Addendum 03 – POST BID

Regarding: **Fore River Apartment – Bidding Documents**

Subject: **Addendum 03 – Post Bid**

The following addendum items apply to the project known as the **Fore River Apartments** located in Portland, Maine.

Project No: 04416 FRA
 Drawing Title:
FIRST FLOOR PLAN

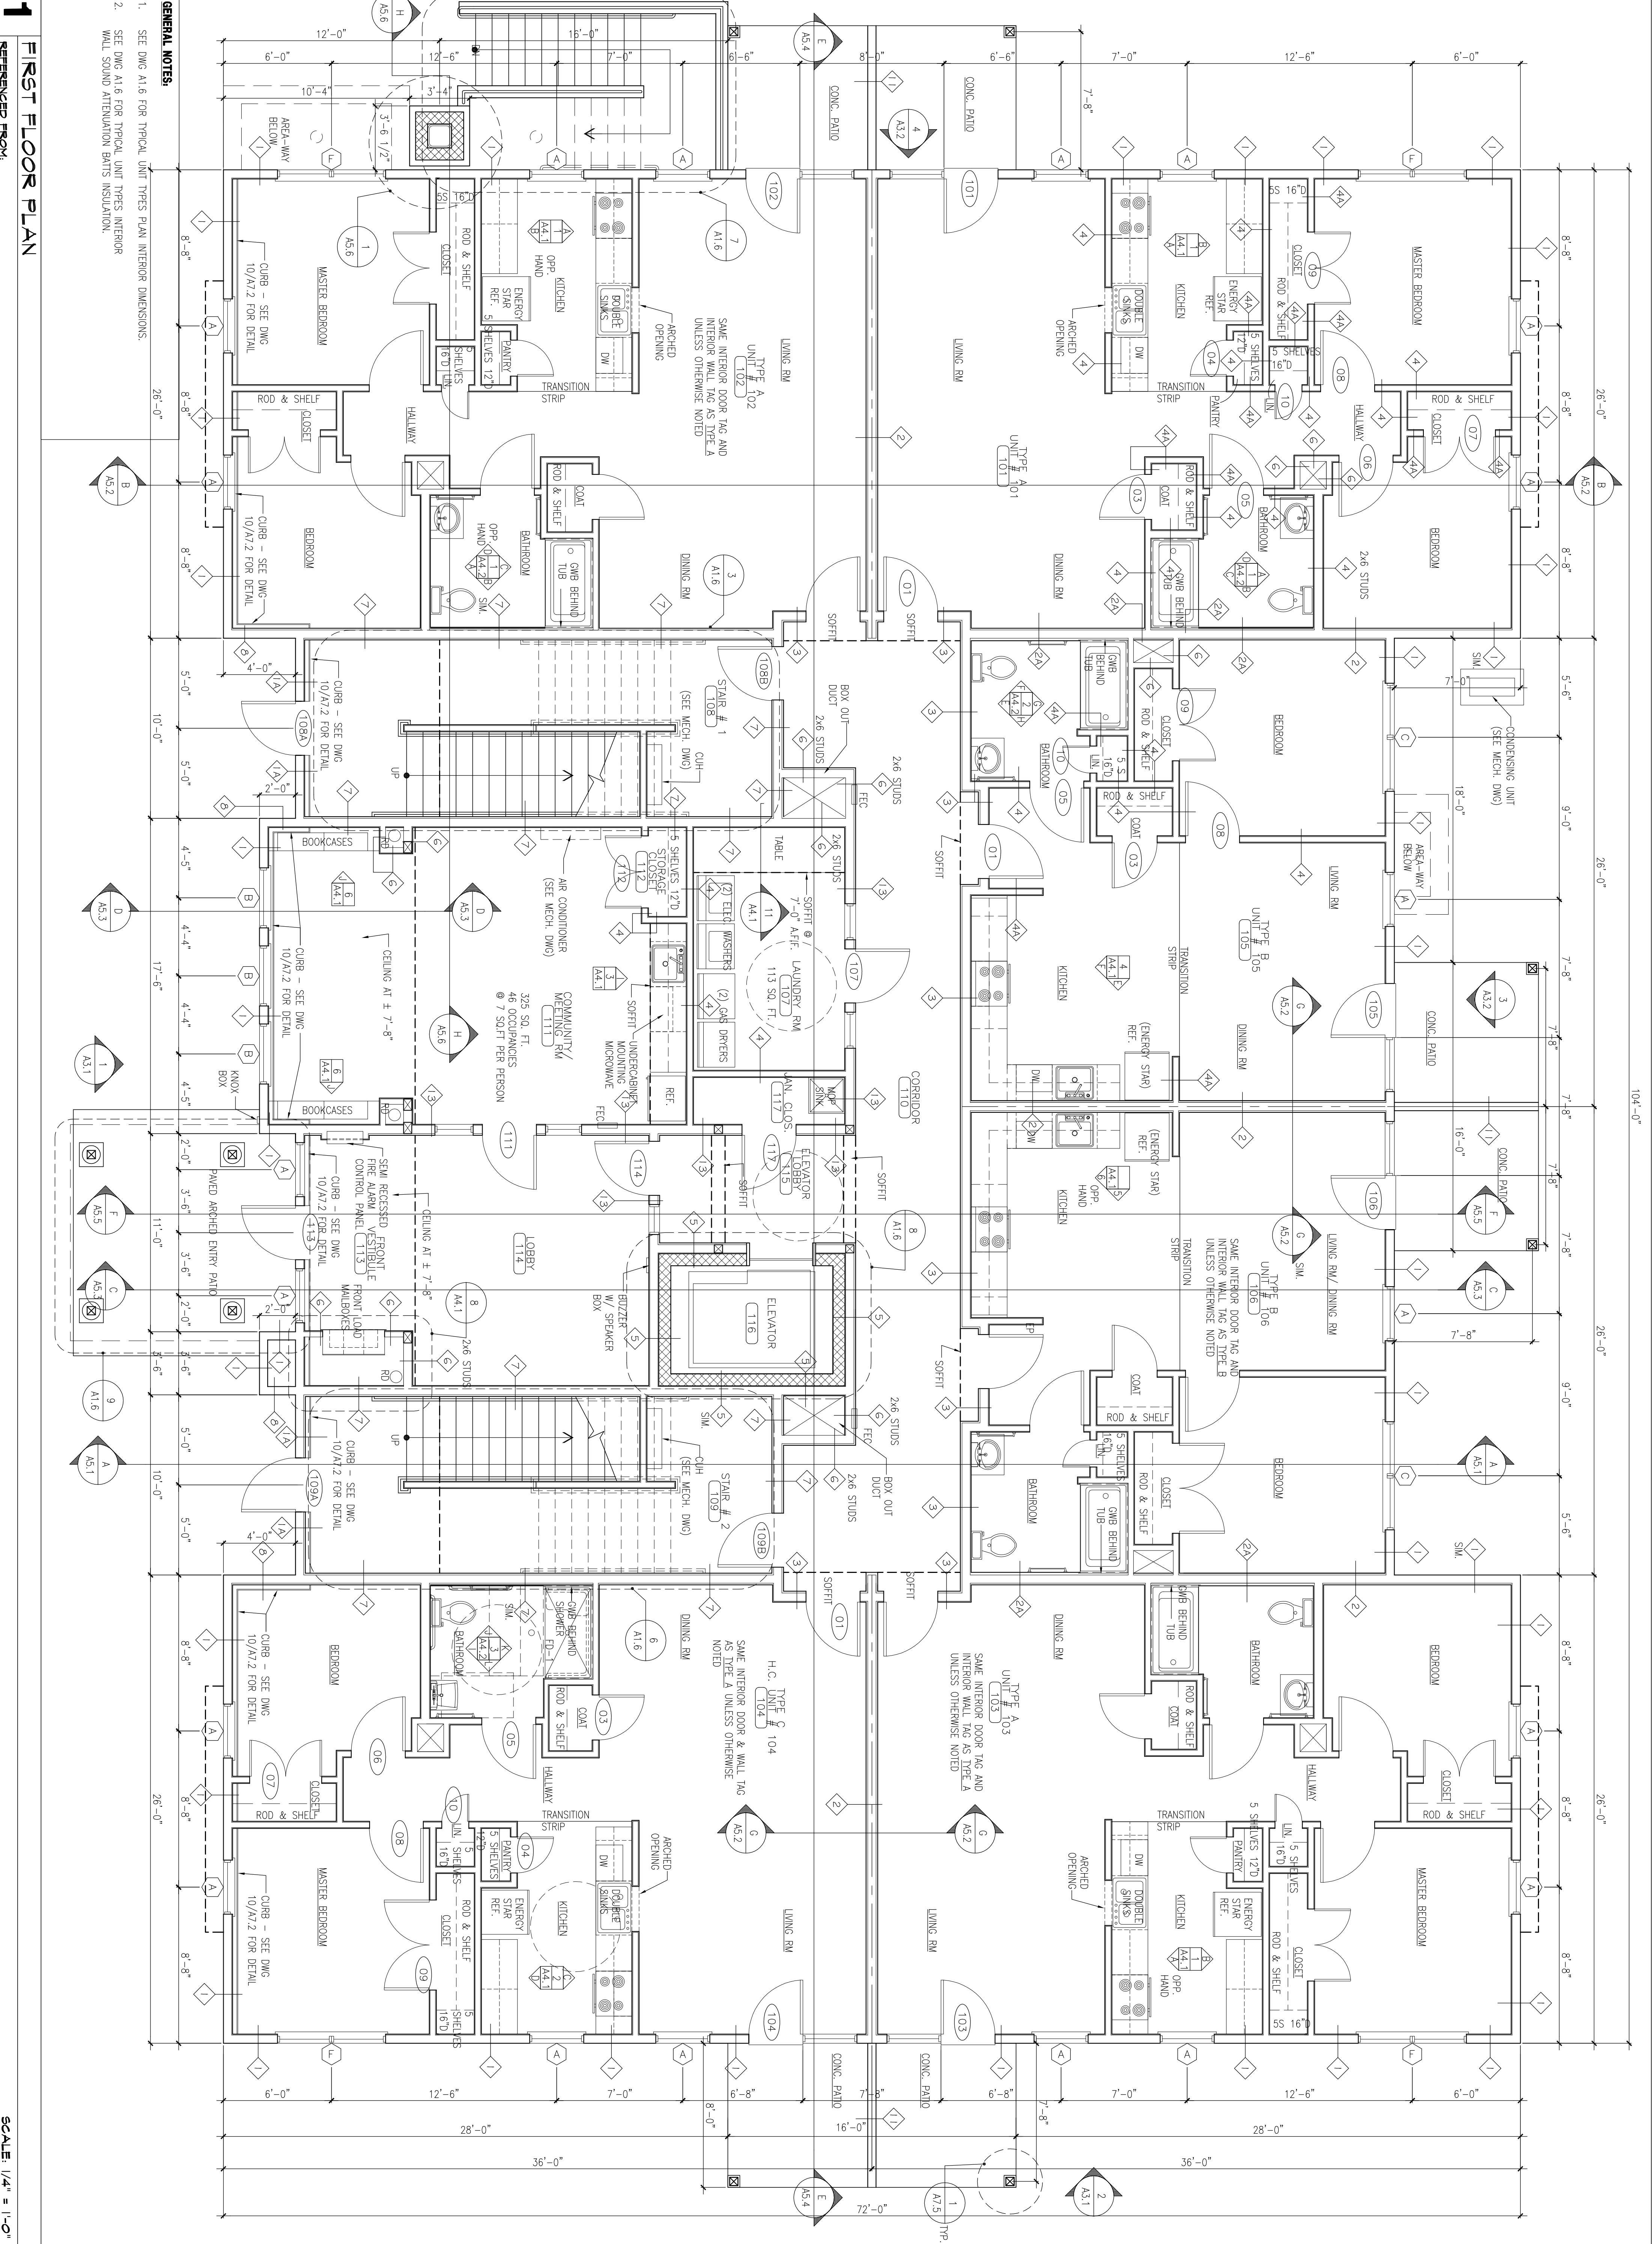
1. See attached drawing **A I.1** for revised Wall Type on Corridor wall which is indicated with revision cloud.
2. Add Wired glass to Door and sidelites No. 107 and 114; Also, add 20 Min. label to Door No. 107, 114, and 117. See drawing A4.3 and Door Schedule for detail.
